**Jeanie Bourke - Re: 159 State St., BP#2014-02869 plan review comments**

I am reviewing this permit application for the change of use for the nursery school. I look for building code compliance and information that is required on the Certificate of Occupancy. I do have some questions I hope you can answer in order to approve this permit.

State Street Church
Second Floor

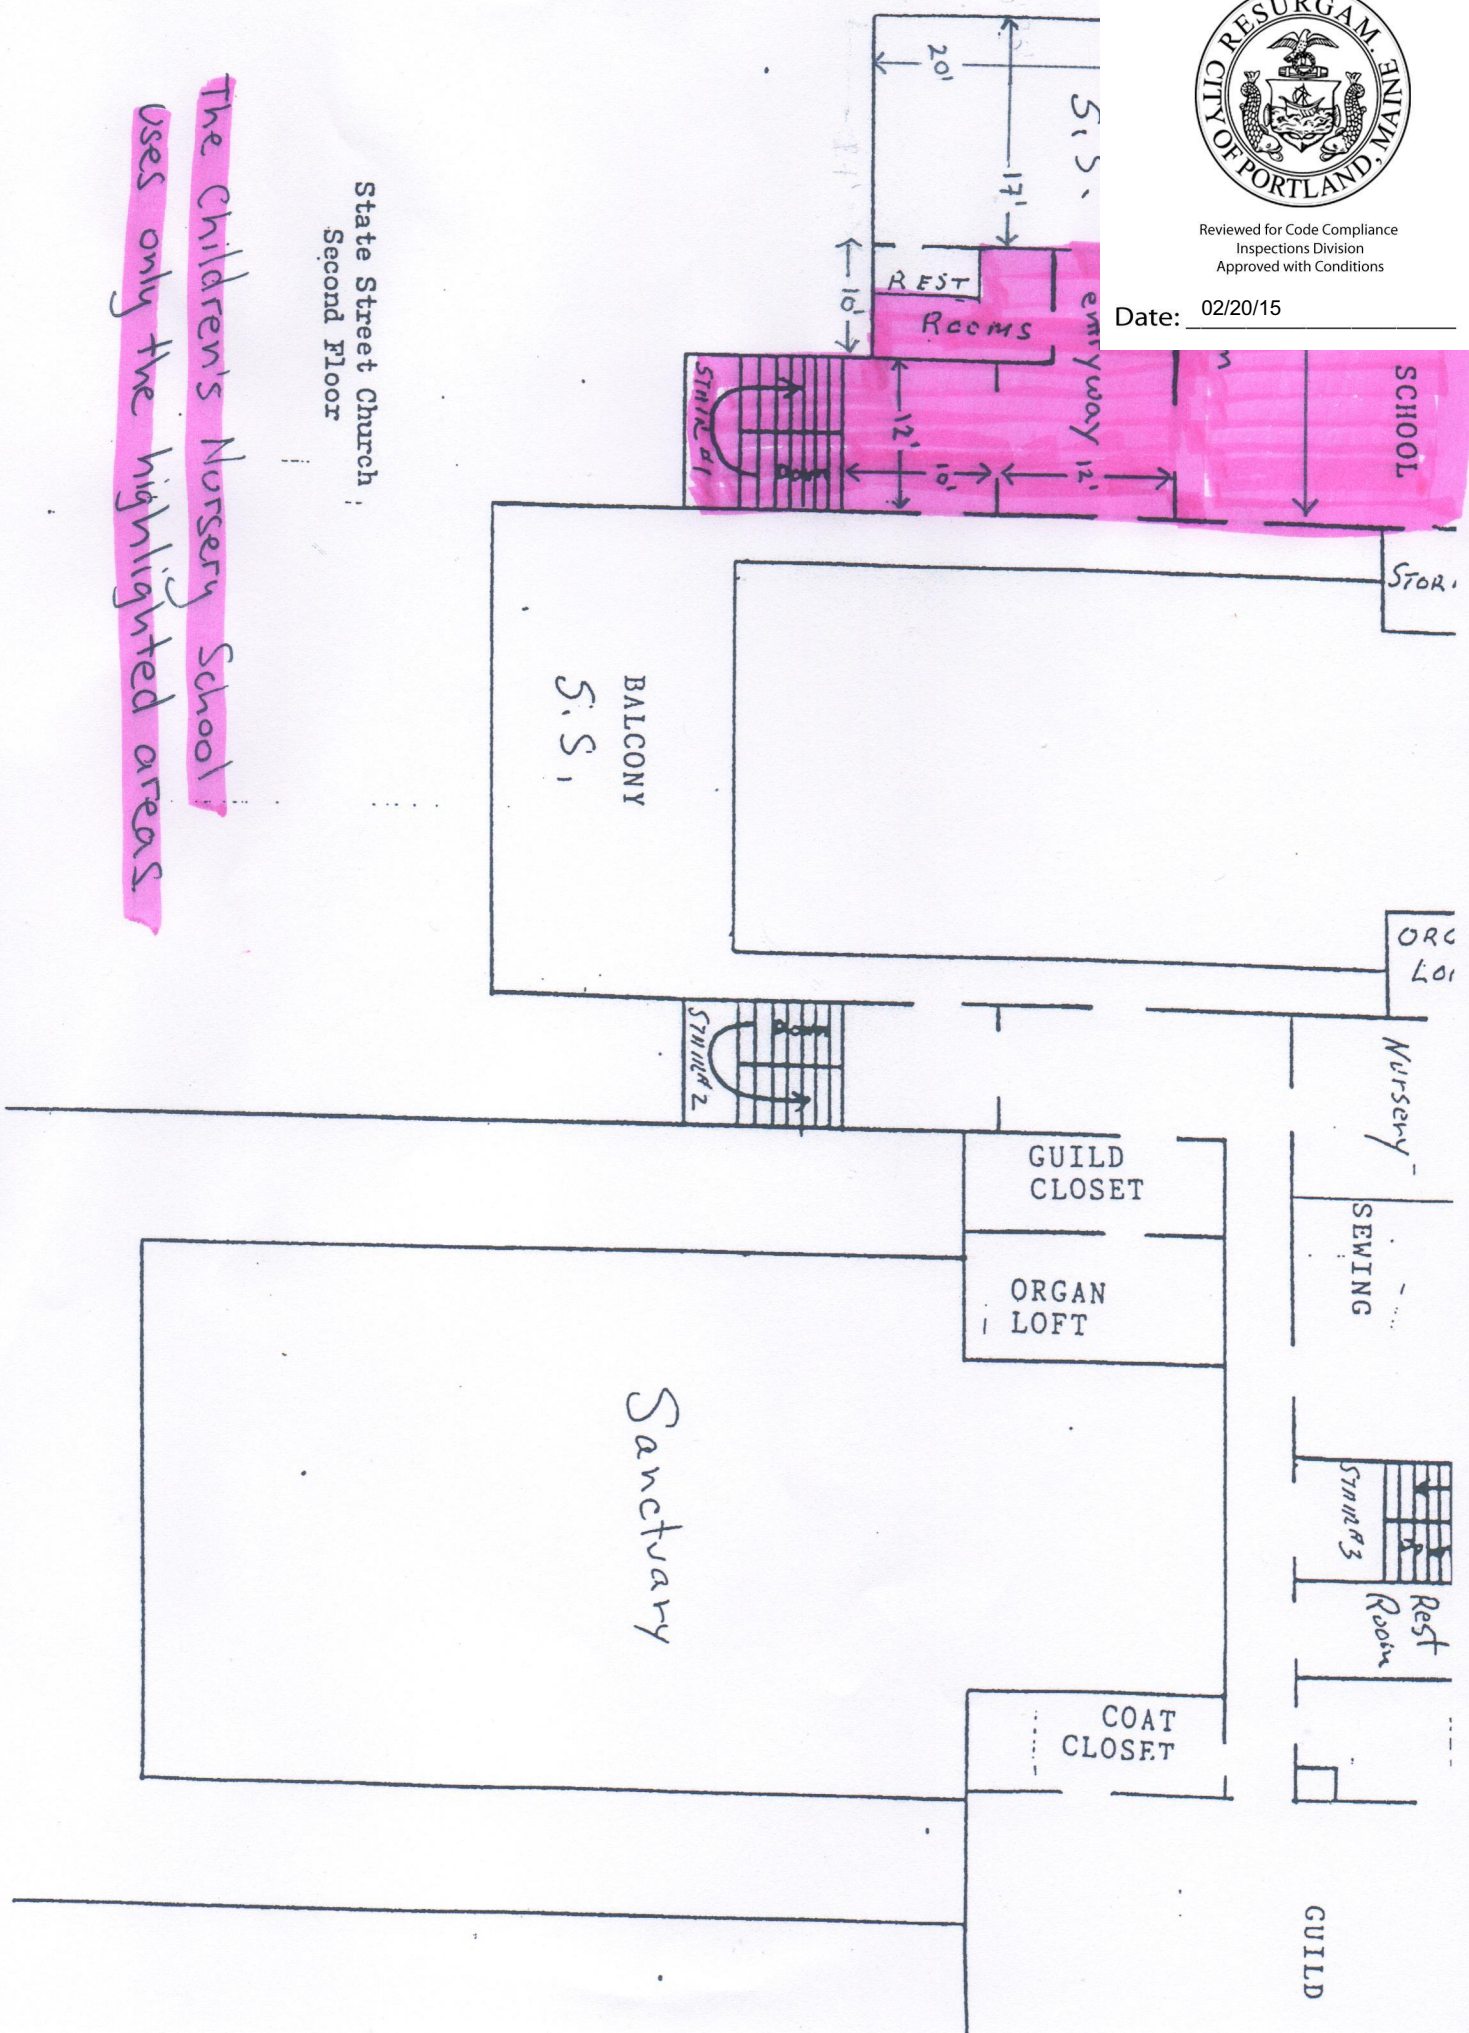
1. Does the building have a sprinkler and fire alarm system?
2. In looking at the 2nd floor plan, it appears the classroom is 702 SF. By code this room calculates to occupant load of 35. What is the typical enrollment for the school? There is another room that is not shaded pink (S.S), 340 SF, is this part of the school, either offices or classroom?
3. Please confirm if there is an exterior stair or fire escape from the classroom. It appears there is on the left side of the plan.

The room adjacent to the highlighted area is not part of our rental. The Church uses it on the weekends. We cap enrollment at 18 (we have 16 right now) and we have 4 adults in the room at all times for a total of 22 possible people.

We do have an external fire escape (as shown on the map) and it was approved for use by the inspector.
